# **Application by Mallard Pass Solar Farm Limited for an Order Granting Development Consent for the Mallard Pass Solar Project – project ref. EN010127**

**Tony Orvis B.Sc Hons. (Botany)  
Unique ID ref. 200335950**

## **ExQ1 - Responses to ExA's First Written Questions**

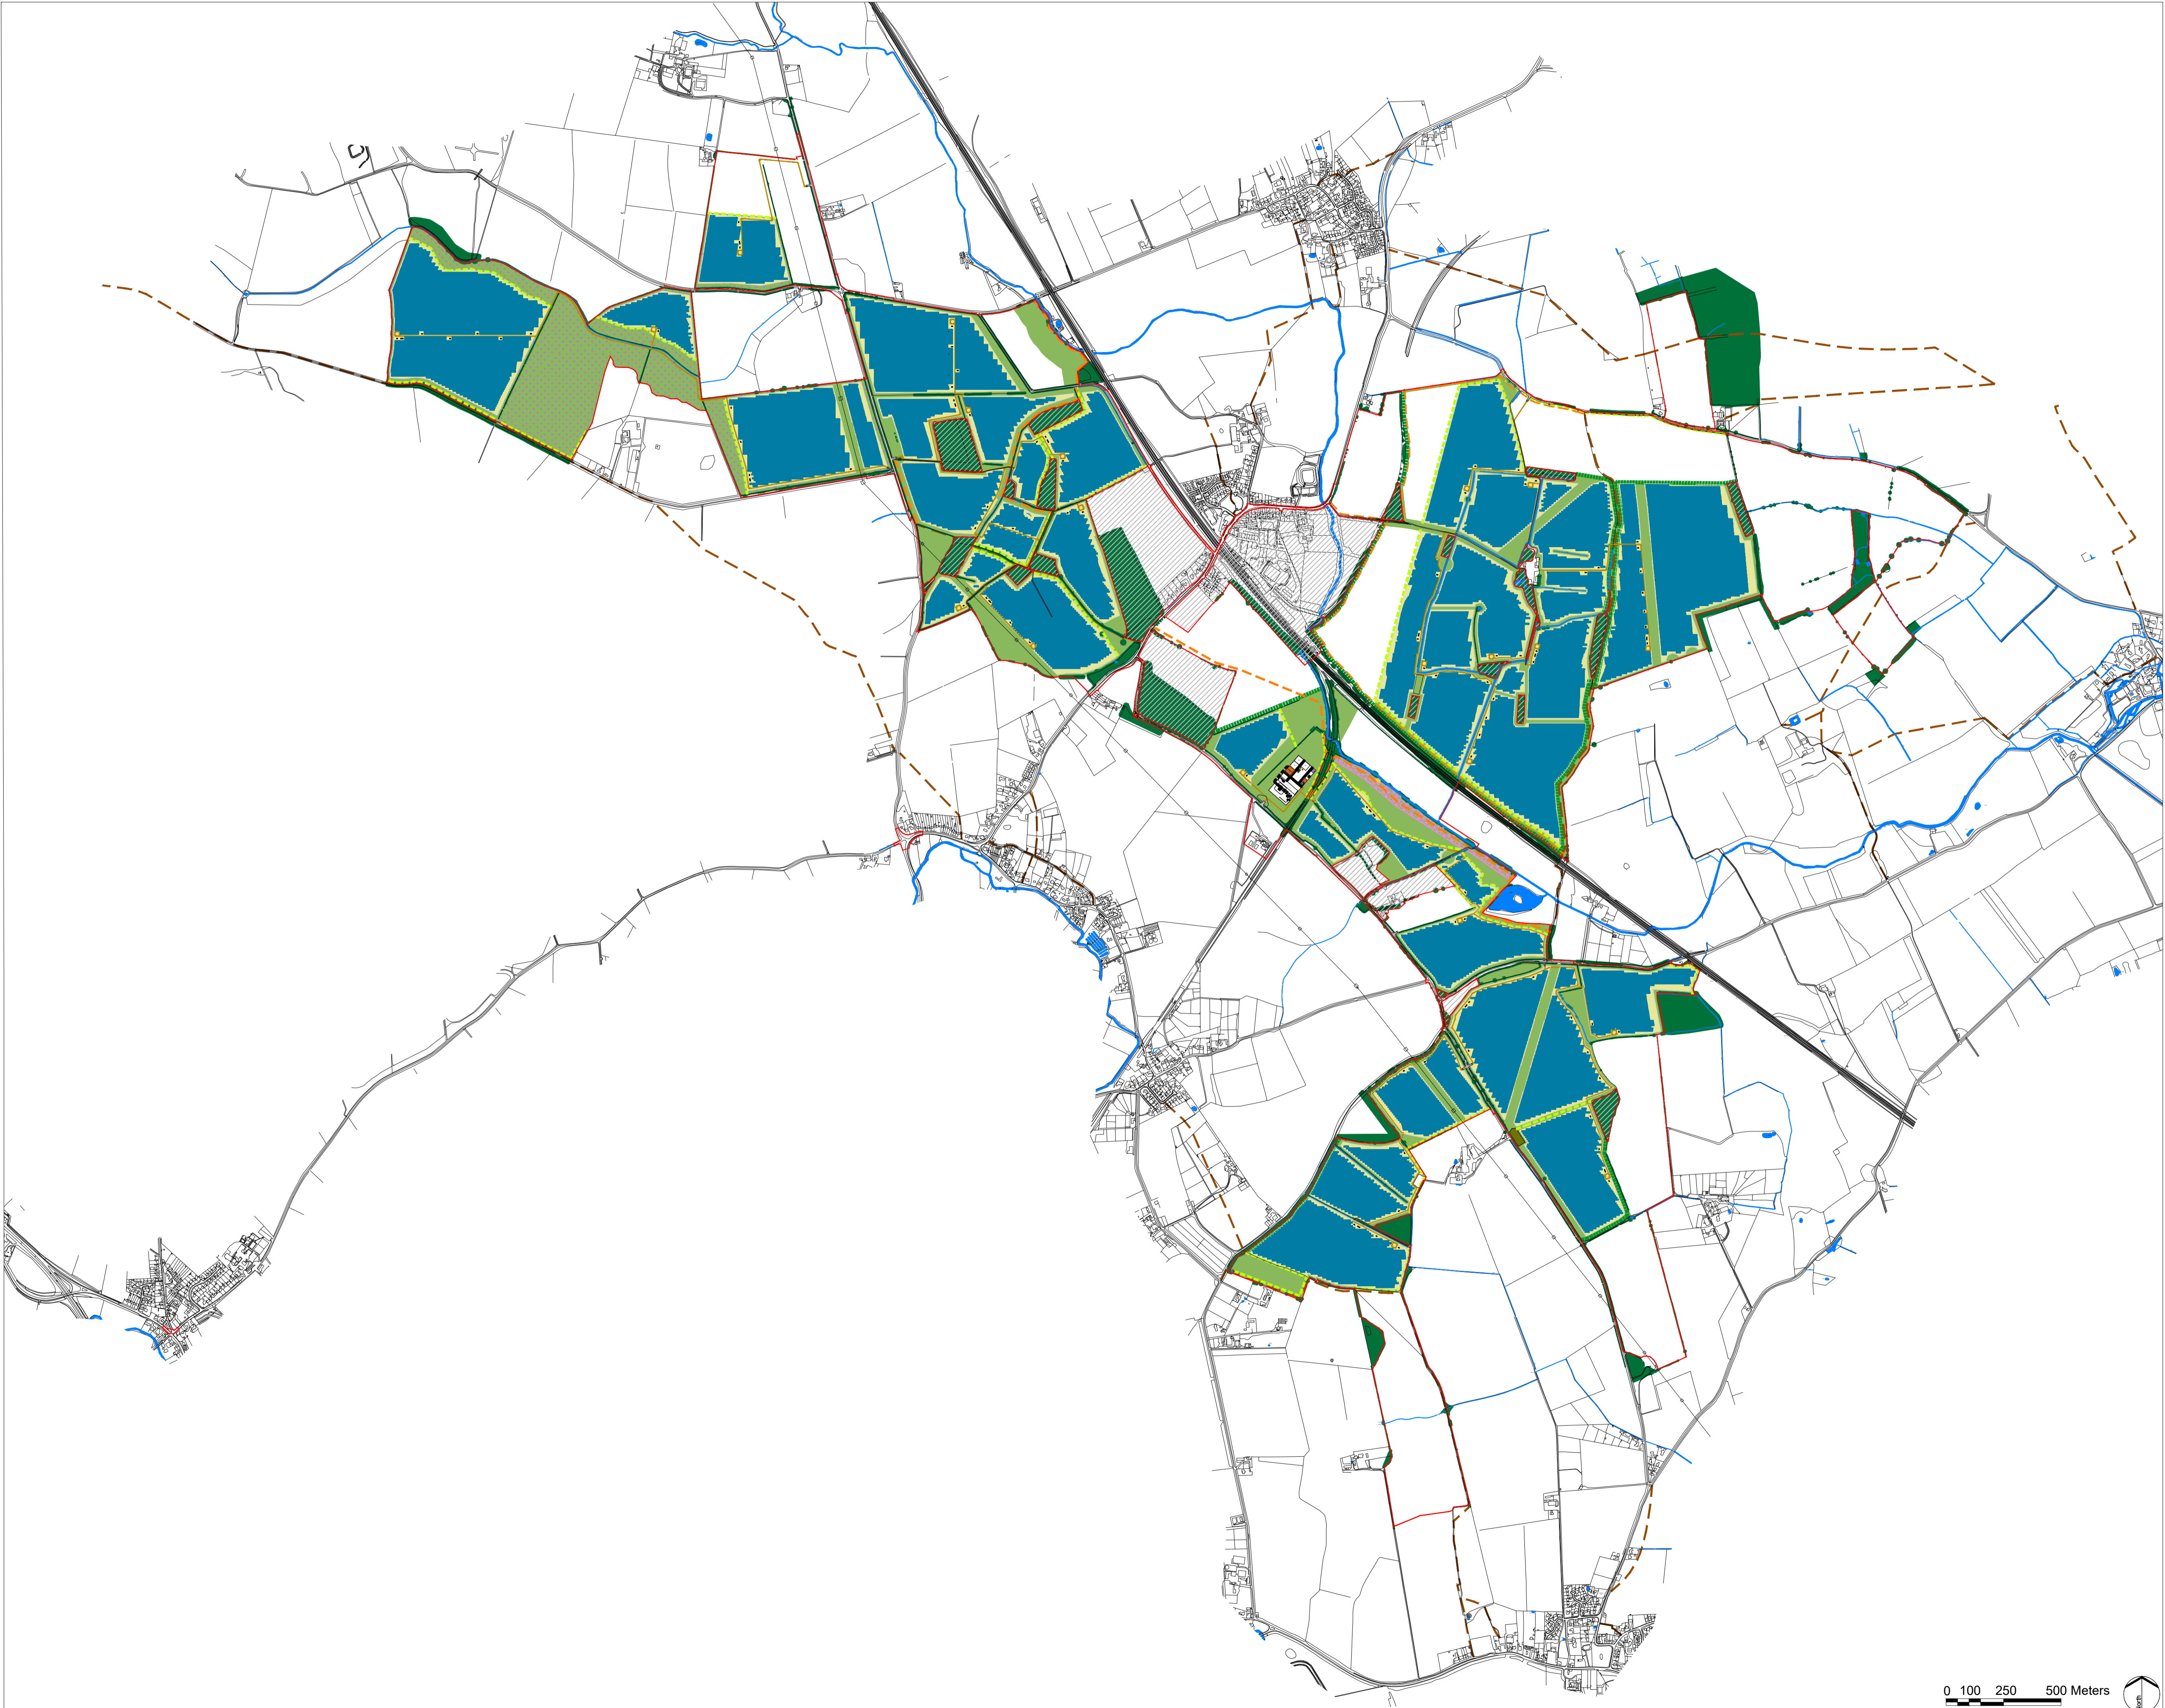
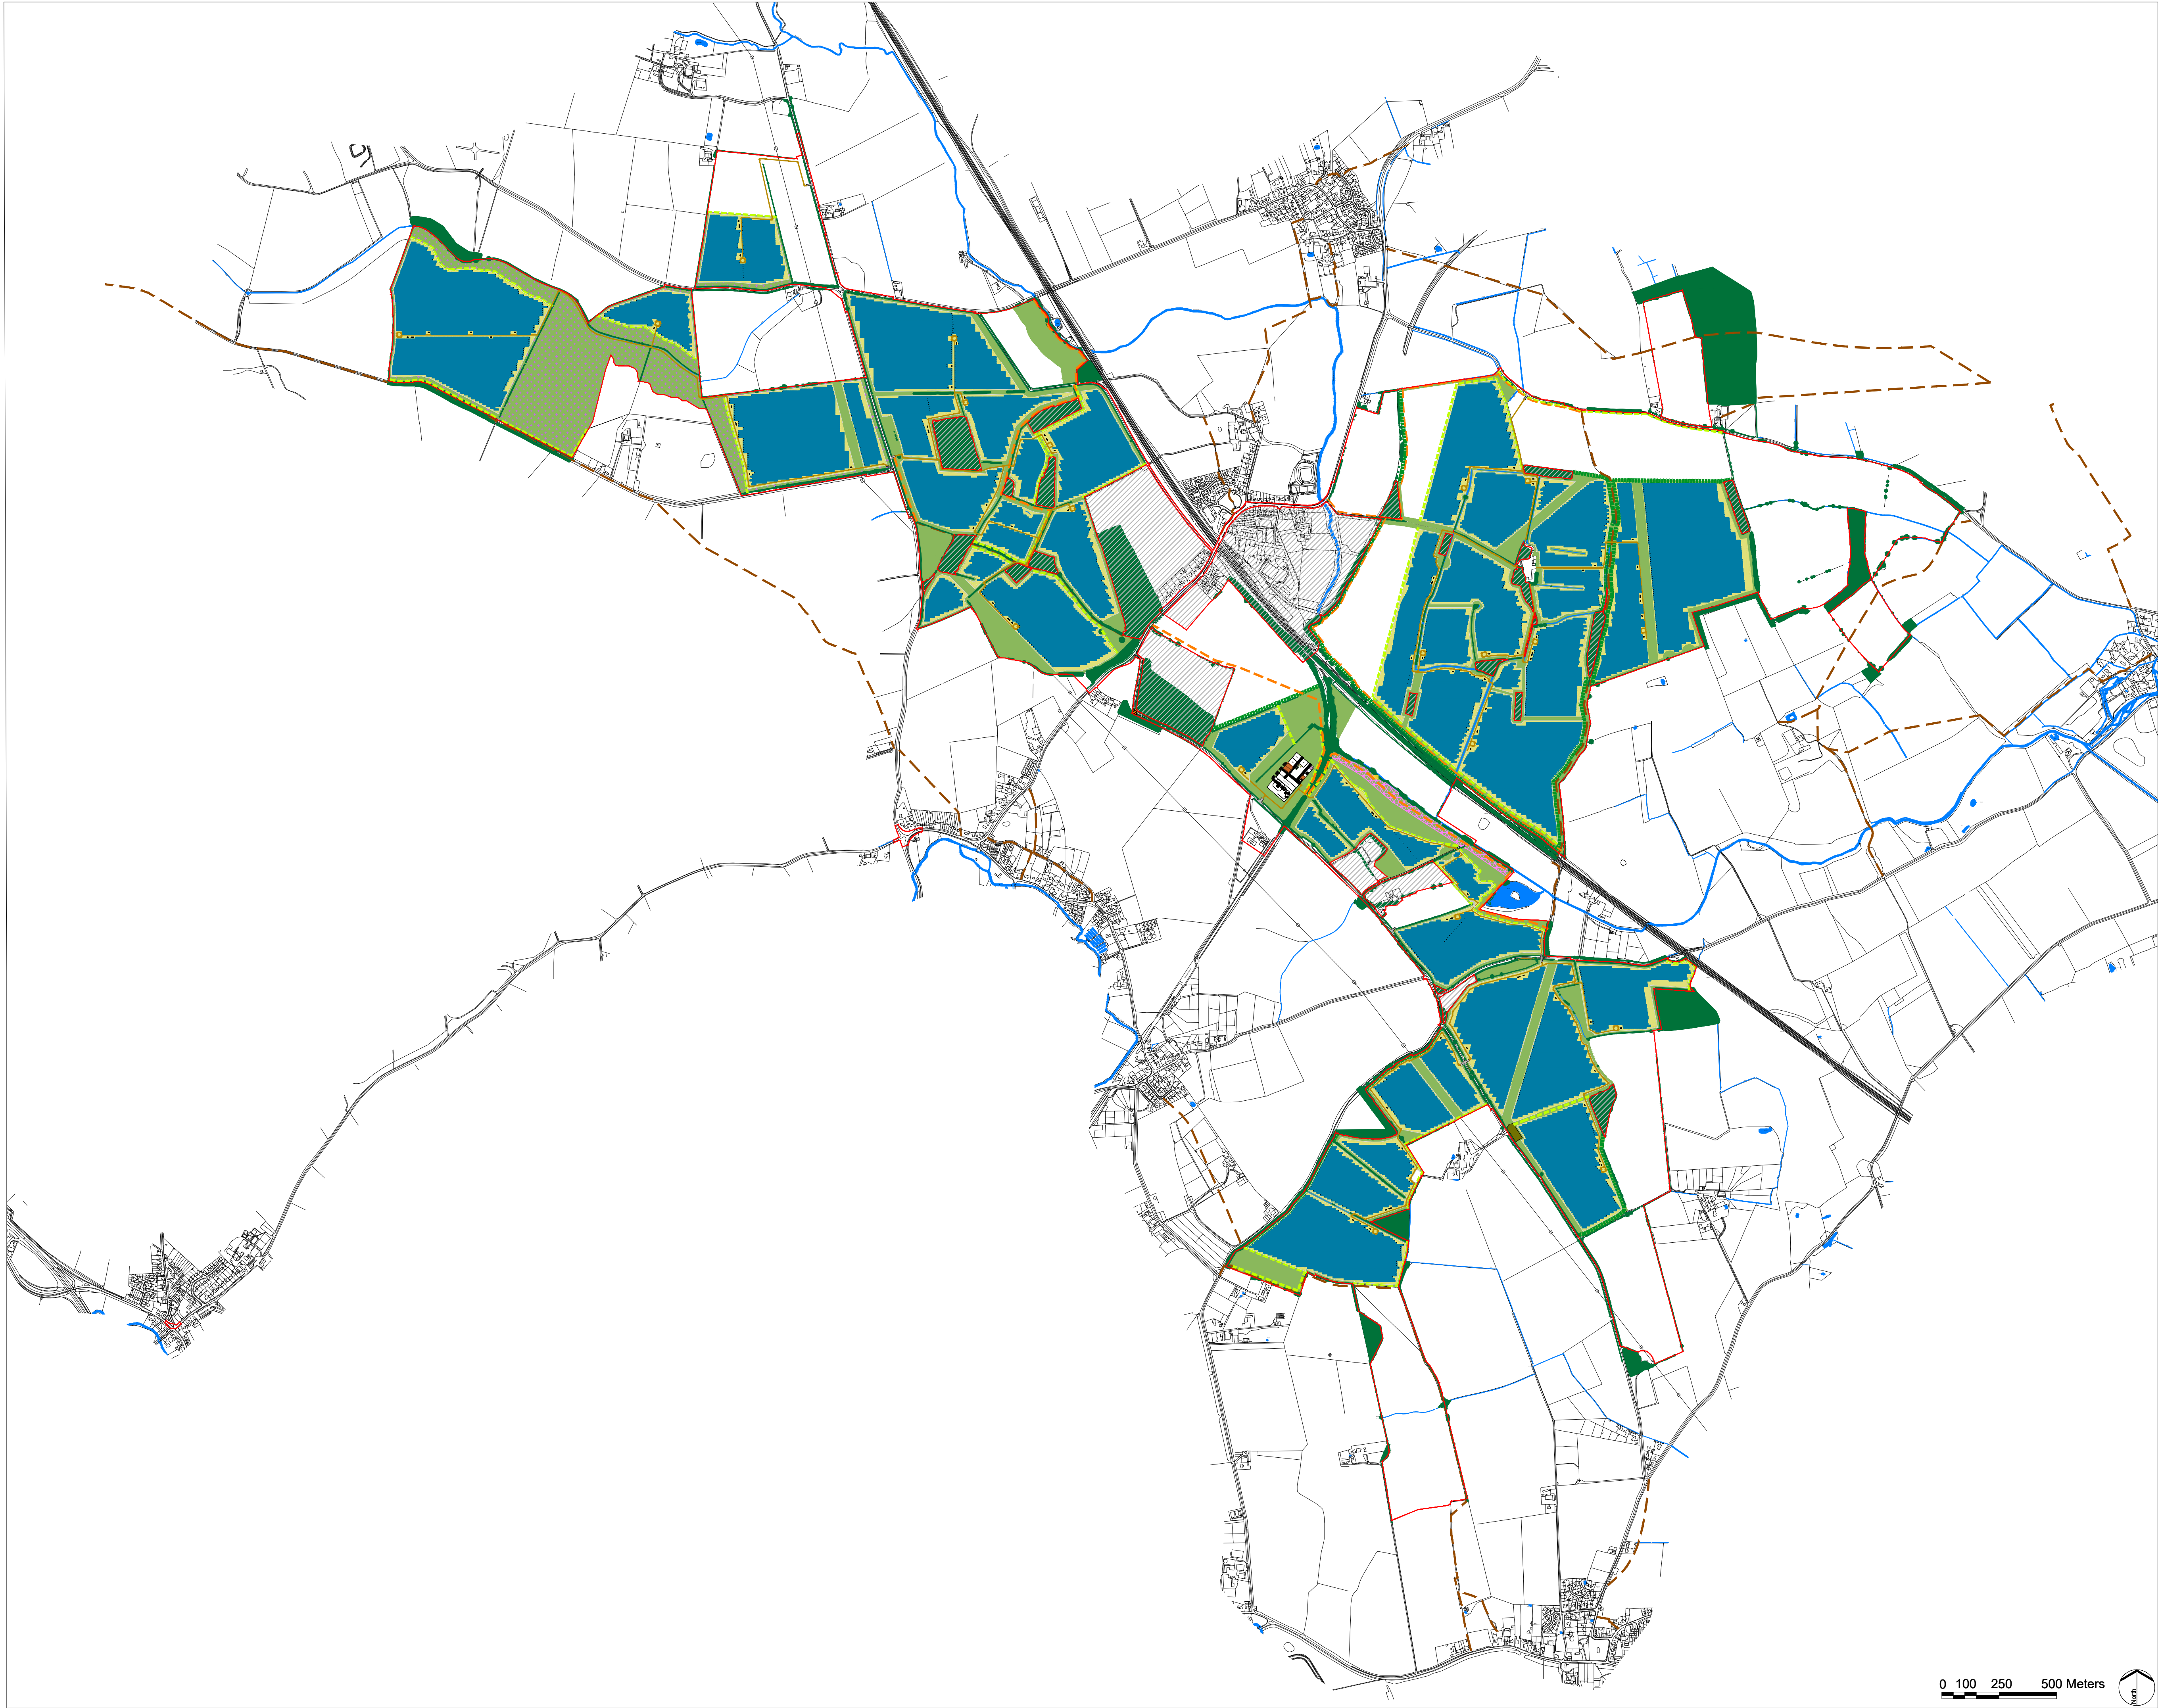
Producing forage, hay, silage or haylage would be impossible. The Applicant does not give the proposed distance between the arrays but states that at a minimum they will be two metres apart “to minimise effects of shadowing and to ensure optimal efficiency.” Although that is the minimum it is highly unlikely that the distance between the arrays will be great enough to accommodate forage harvesters.
